PLANNING CONSULTATION RESPONSE

Application No	2026/0657
Proposal	Erection of 1no. building for industrial (class E(g)(iii)/B2) or storage and distribution (class B8) use with associated yard, parking, landform and landscaping (Reserved matters of the outline part of hybrid planning permission 2019/1573) for Unit 6 seeking approval of access, appearance, landscaping, layout and scale.
Address	Land to the north and south of Dearne Valley Parkway, Hoyland, Barnsley
Date of Consultation Reply	09/09/2025
Consultee	Katie Lawrence, Planning Ecologist

- Unit 6 Redline
- Artificial unvegetated unsealed surface
- Built Environment: Buildings/hardstanding
- Ornamental Planting
- Amenity Grassland
- Mixed Scrub
- Broadleaved Woodland
- Native species-poor hedgerow
- Native species-rich hedgerow with trees
- Individual trees

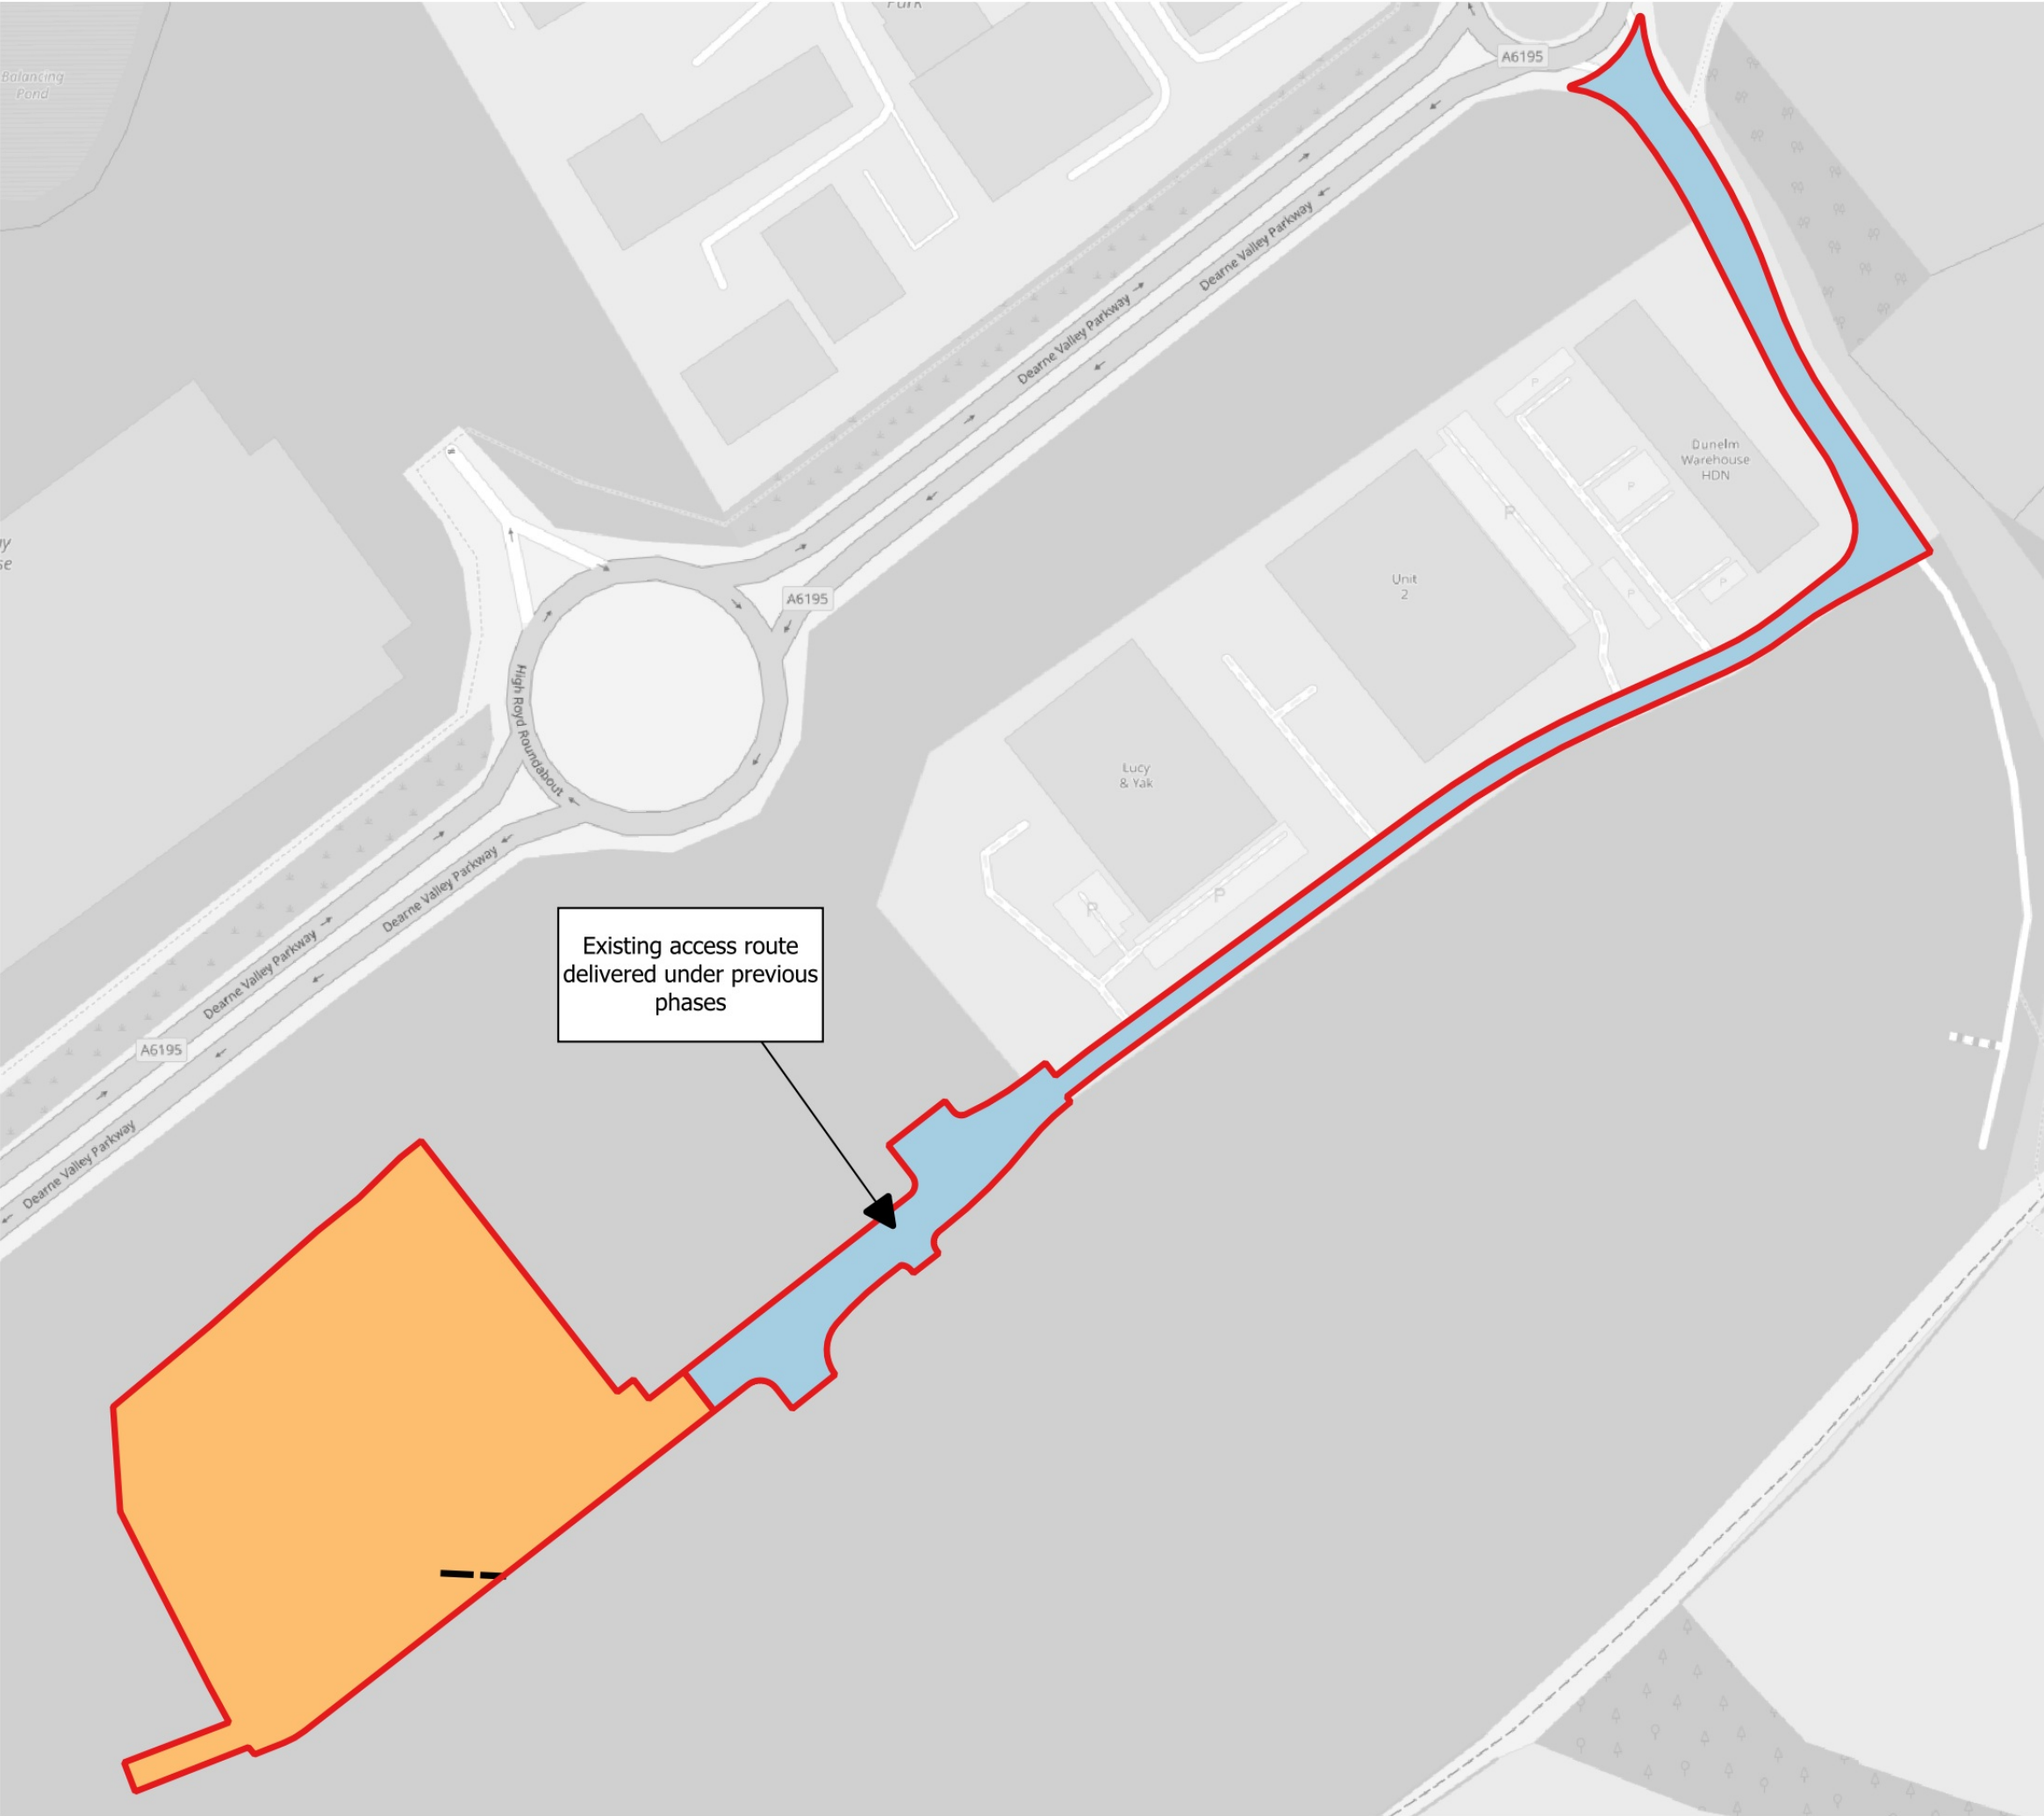
Figure 1 of the document shows the proposed location of the bird and bat boxes; however, it does not show locations for the log piles. Can this be added? It is shown on the proposed landscape plan (drawing no. 12006-6-SFW-XX-XX-DR-L-1001) but would ideally be included on figure 1 for completeness.
